Recommendation Report for Planning Permission for Works or Extension to a Dwelling

REF NO: M/129/21/HH

LOCATION: 34 The Layne
Elmer
PO22 6JL

PROPOSAL: Removal of existing side extension & erection of two storey side extension & canopy roof over existing front projection

Ground floor plan
1 : 50

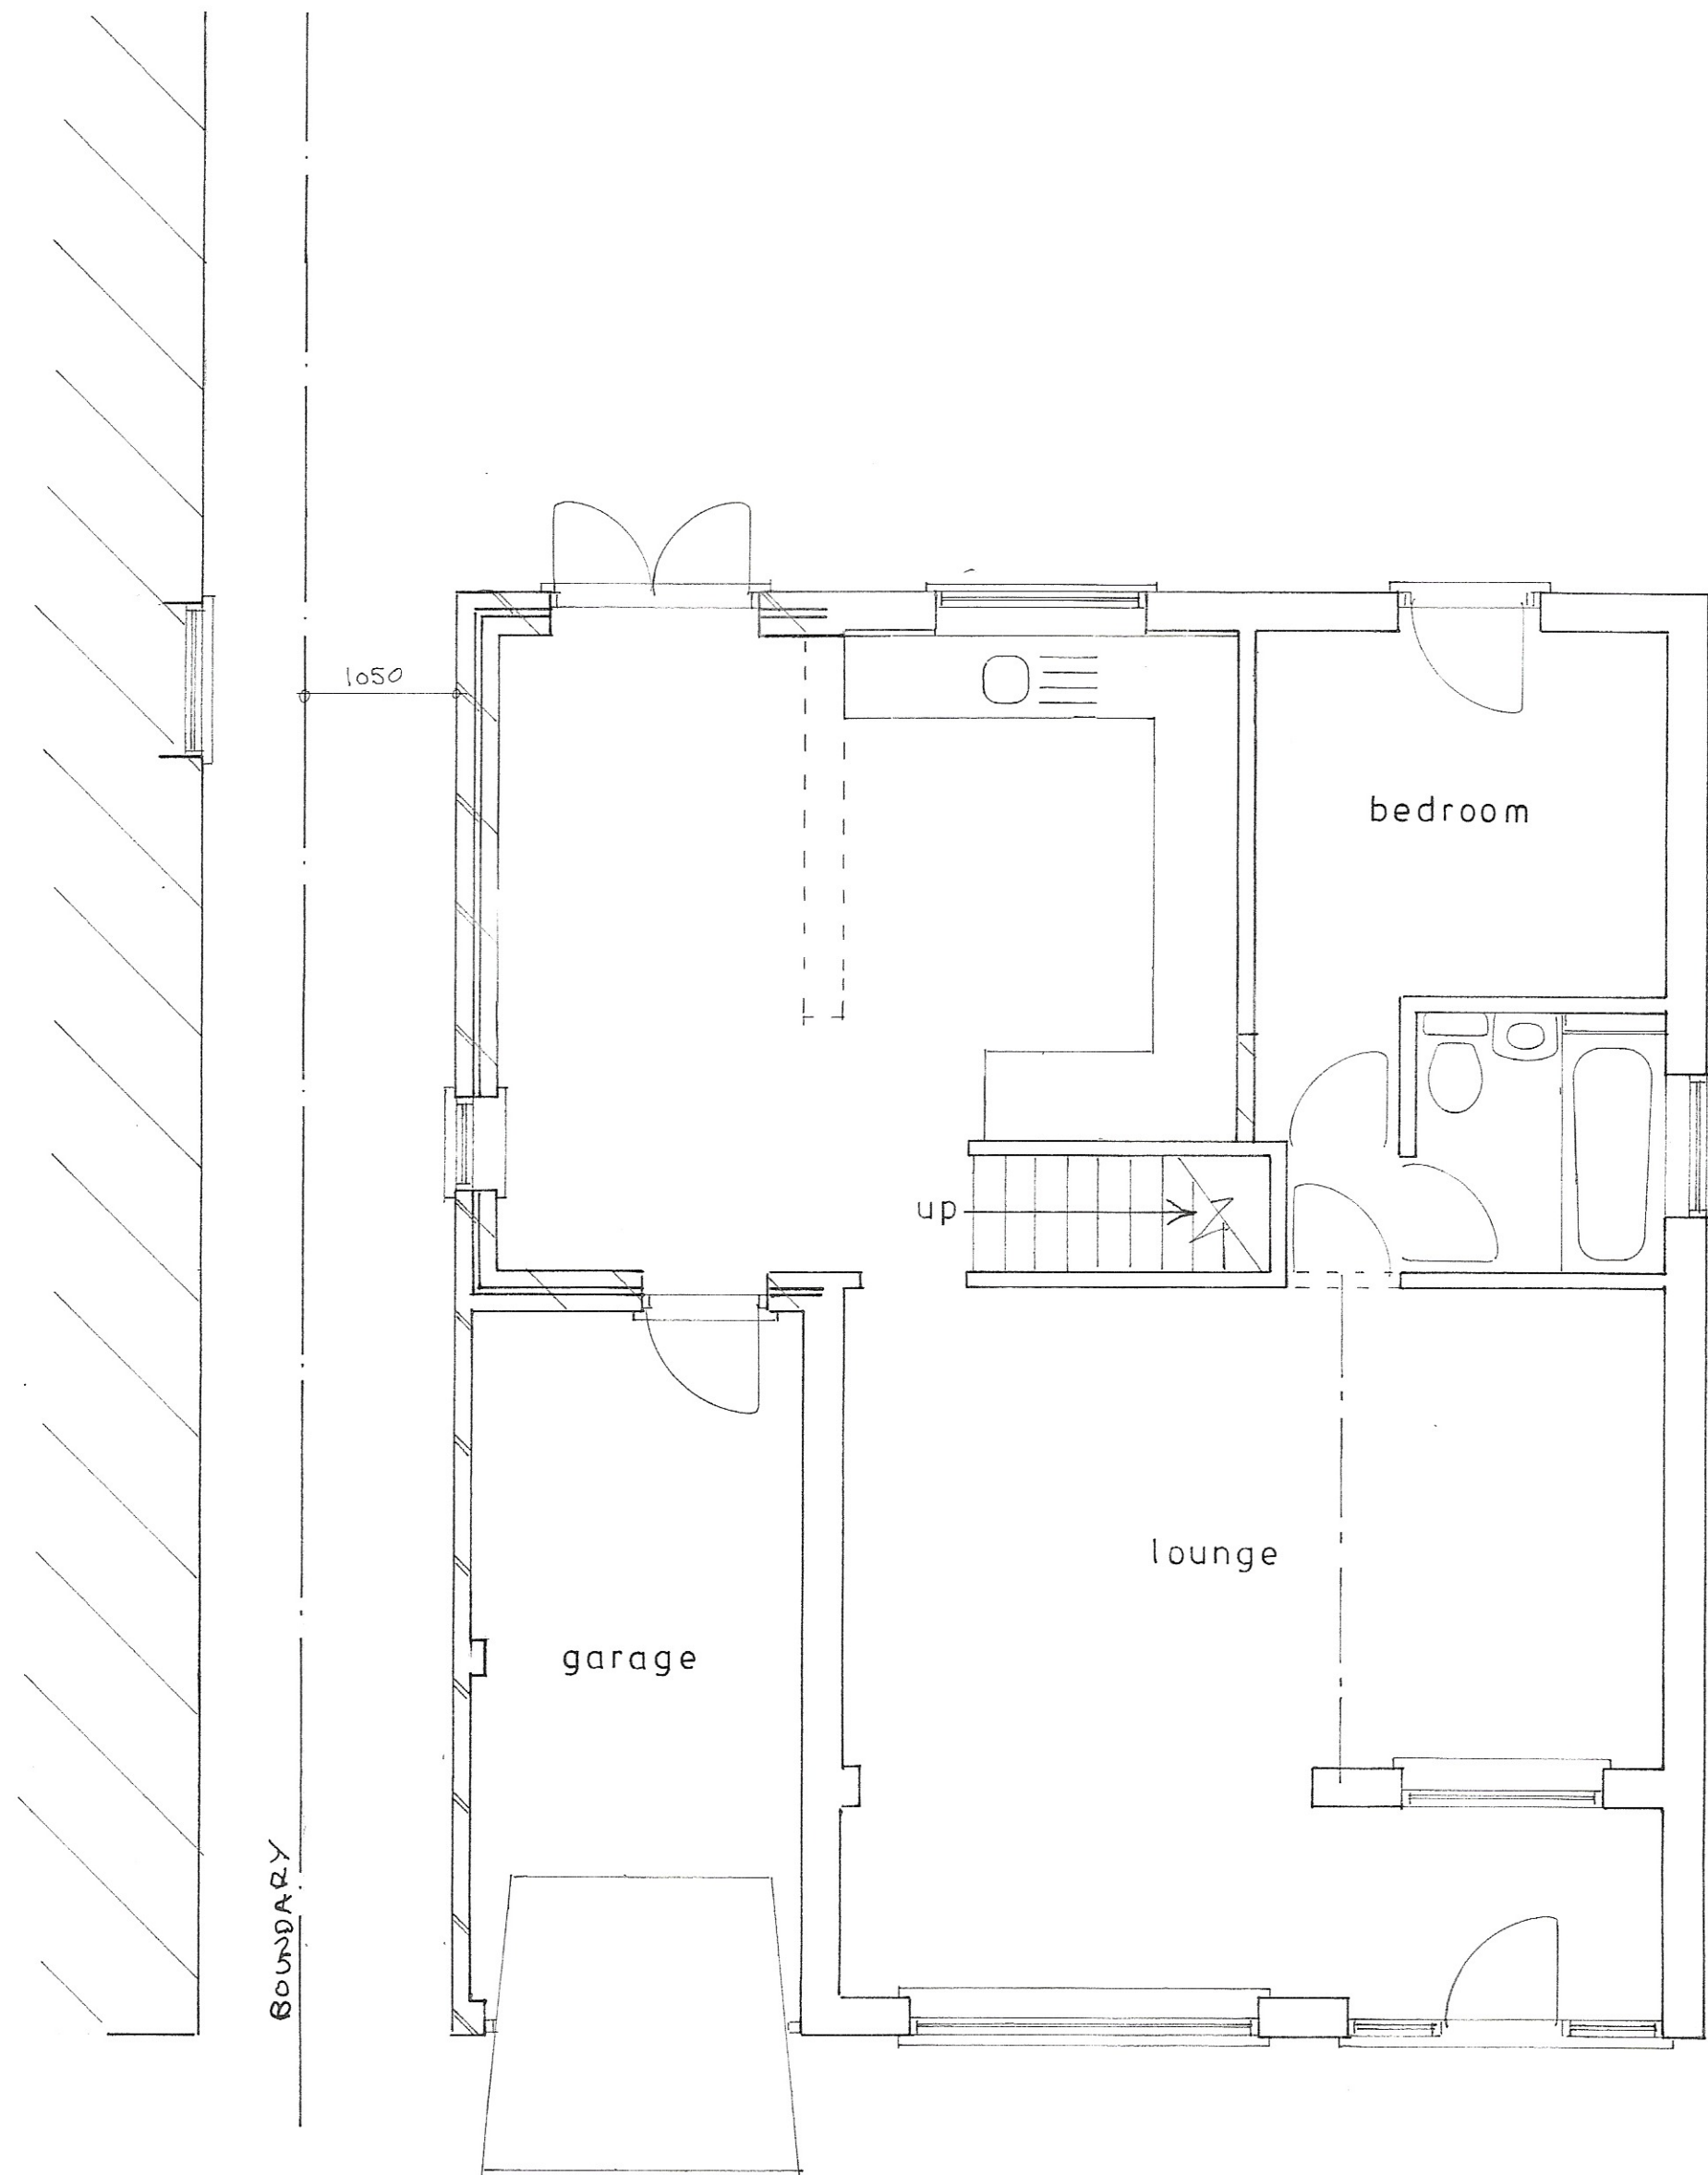
This approval relates to the Ground Floor Plan shown on Sheet 2 and the First floor plans and Elevations shown of Sheet 2 a, although a small inconsistency can be seen to the northern elevation on sheet 2 a. The inconsistency shows the previous scheme.

sheet 2 a of 3

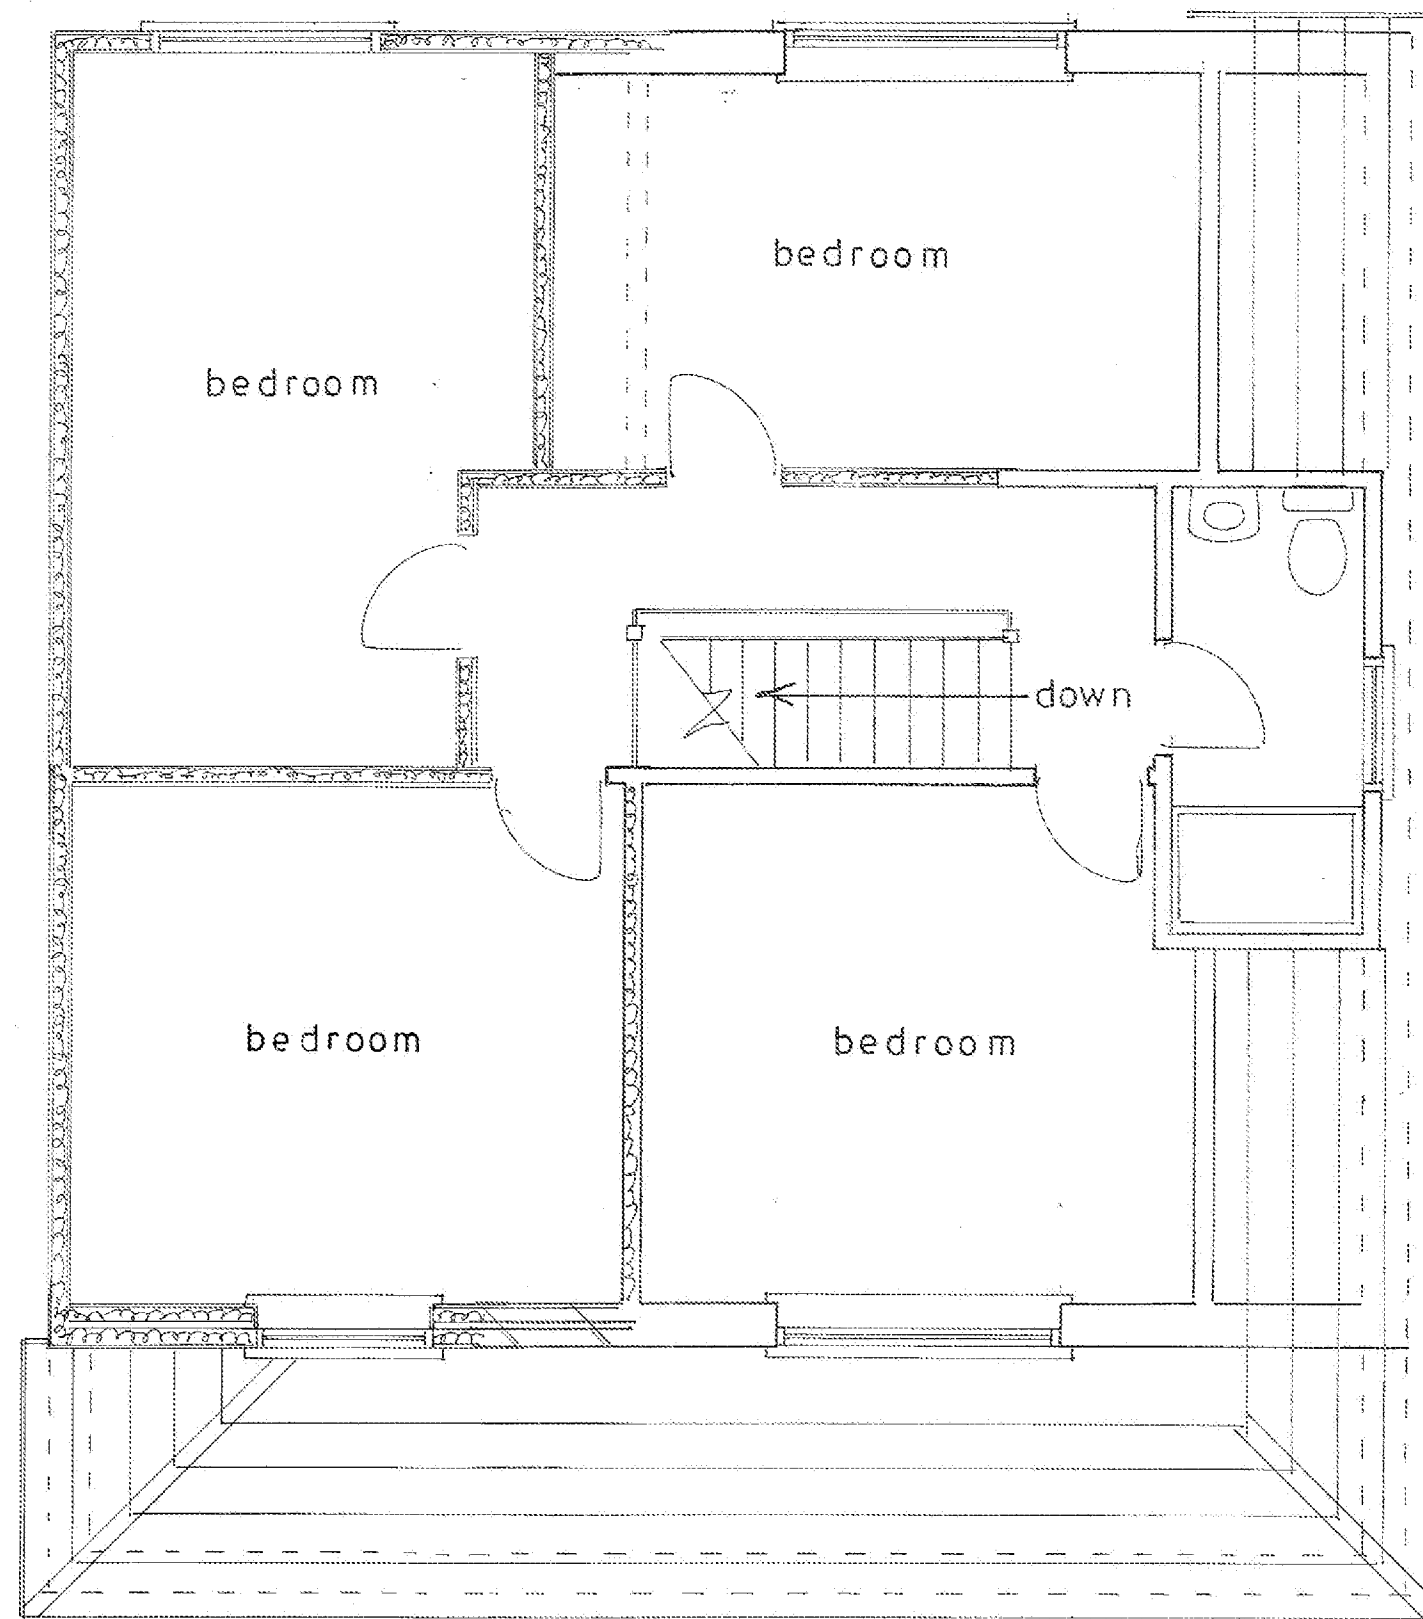
The side extension does not meet with some of the design guide criteria in that it is not positioned away from the boundary by 2m at first floor level and that it protrudes within the 70-degree line running up from the boundary. It does however have a lower ridge height and amendments have been made to the application to position the first-floor eastern elevation 1.6m back from the ground floor, as such it is considered acceptable.
